## Department of Primary Industries

**Eagleton Hard Rock Quarry (SSD\_7332)  
Request for input into Secretary's Environmental Assessment Requirements**

Comment by DPI Water

Figure 3 – Site Characteristics and Features
Source: Eagleton Rock Syndicate

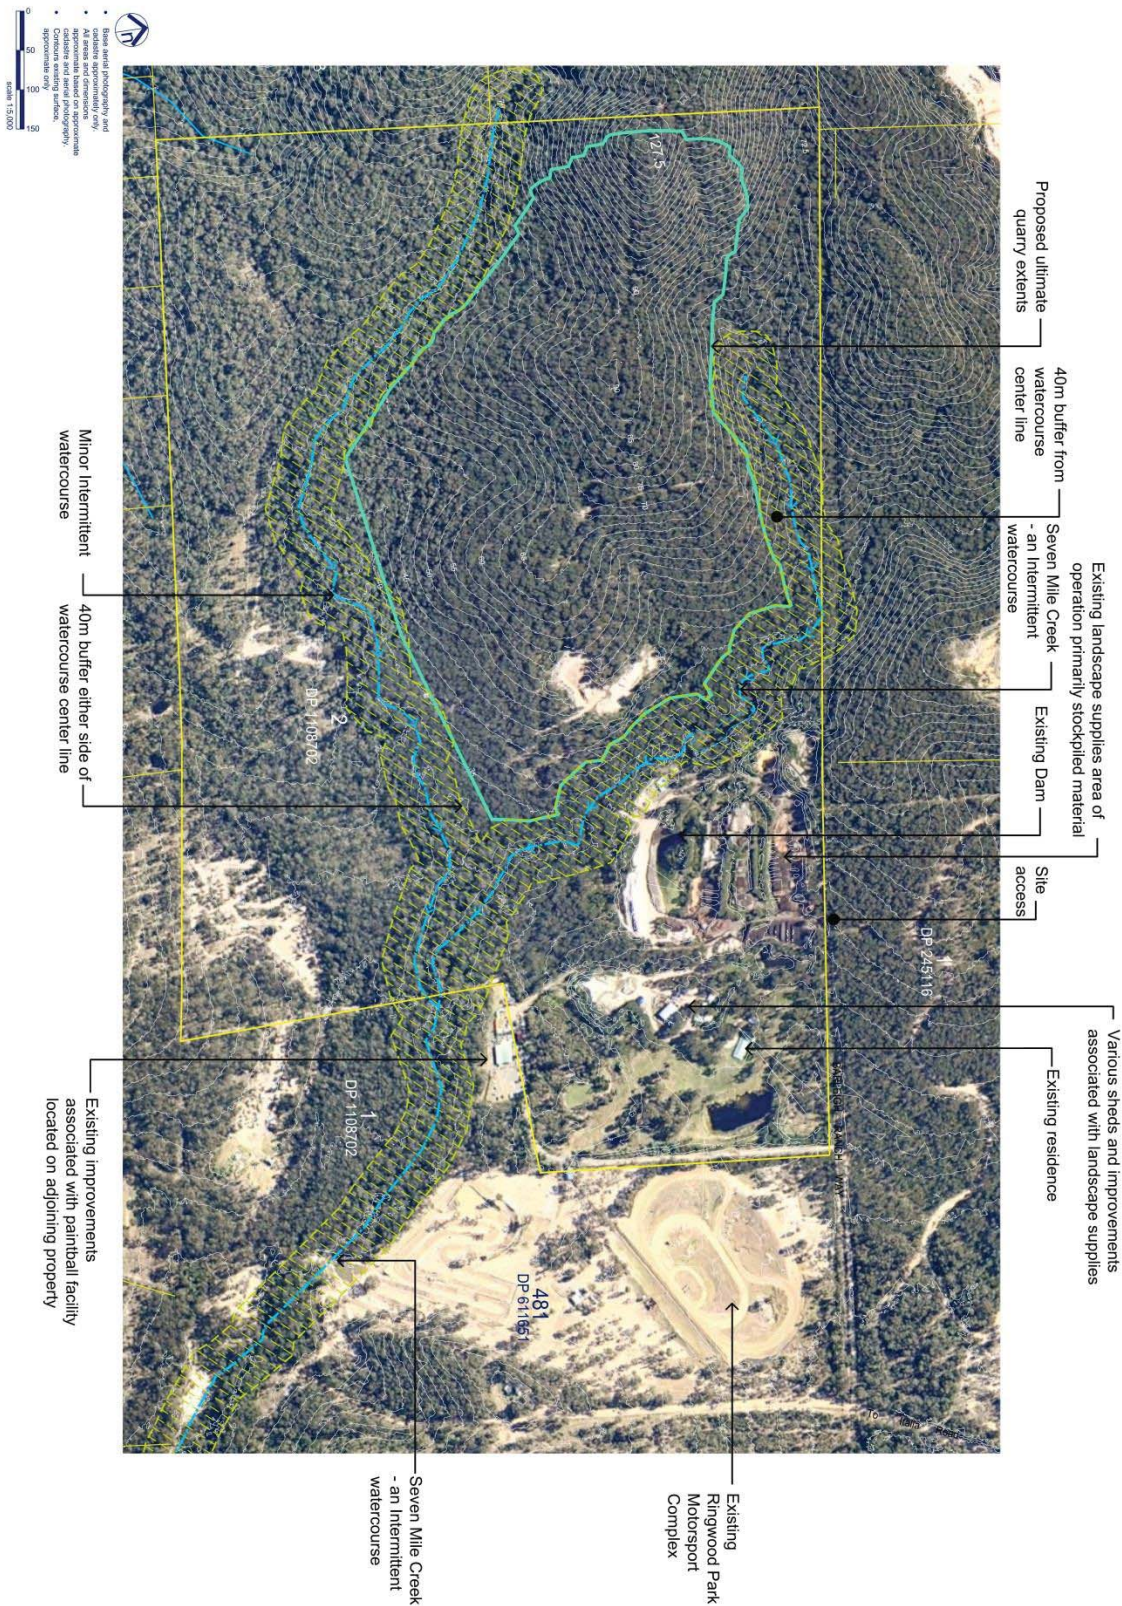
Additionally although state significant developments are exempt from requiring a controlled activity approval, DPI Water Guidelines for works on water front land should still be followed. It is noted that in Figure 3 the water course buffers have been measured from the water course centre line. The proponent must be aware

that buffers for the vegetated riparian zones must be measured from the highest bank of the water course and not the centre line. The relevant guideline is the "*Guidelines for Riparian Corridors on Waterfront Land*" which can be accessed at the following link:
